13 August 2021

Re: St John of God Richmond Hospital Redevelopment (SSD-10394) Response to Submissions

I refer to the letter from Ms Megan Fu, Acting Team Leader Social Infrastructure Team from the NSW Department of Planning Industry and Environment (DPIE) dated 16 July 2021 regarding the response to agency submissions for the State Significant Development of the existing St John of God Richmond Hospital at 177 Grose Vale Road, North Richmond, 2754 (Lot/Section/Plan no: 111-/DP1134453) in Hawkesbury.

Figure 47. Bushfire attack levels – option 2 (without easement)
Source: Blackash

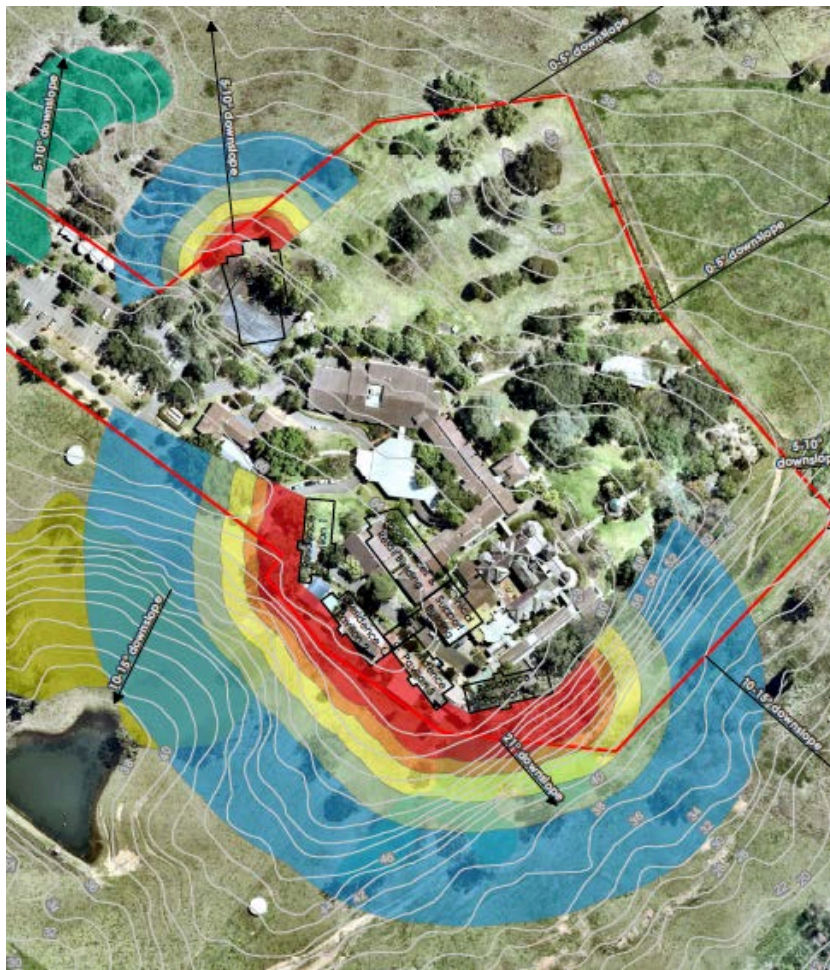
3. *Provide an explanation for the use of 1090 Kelvin in the bushfire modelling for the Wellness Centre, as the facility is a SFPP development which ordinarily uses 1200 Kelvin.*

4. *Address the appropriateness of the proposed Wellness Centre and two of the proposed Residential Pavilions located within BAL-FZ – the proposed construction requirements are not commensurate with their location.*

Following the discussion with DPIE on the 4 August 2021, St John of God have repositioned Pavilion 4 (see Attachment 1) so that it is within the existing building footprint and the Wellness Centre (see Attachment 2) to be at BAL 29. Attachment 1 shows the existing buildings and the proposed redevelopment with commensurate Bushfire Attack Levels (BAL) across the site shown at Attachment 5 and 6.

The buildings have been located having regard to the infill provisions within PBP. Following consultation with DPIE, the Wellness Centre has been moved to 13m from the boundary and is within BAL 29. Pavilion 4 has been repositioned to be no closer to the hazard than the existing building line. See Attachment 1, 2, 5 and 6.

Following the meeting with DEPI, the Wellness Centre has been moved 13m from the boundary and is within BAL 29 (see Attachment 6). It is proposed that the entirety of the Wellness Centre is built to BAL 29 in accordance with AS3959.

Following the meeting with DEPI, the Wellness Centre has been moved 13m from the boundary and is within BAL 29 (see Attachment 6). It is proposed that the entirety of the Wellness Centre is built to BAL 29 in accordance with AS3959.
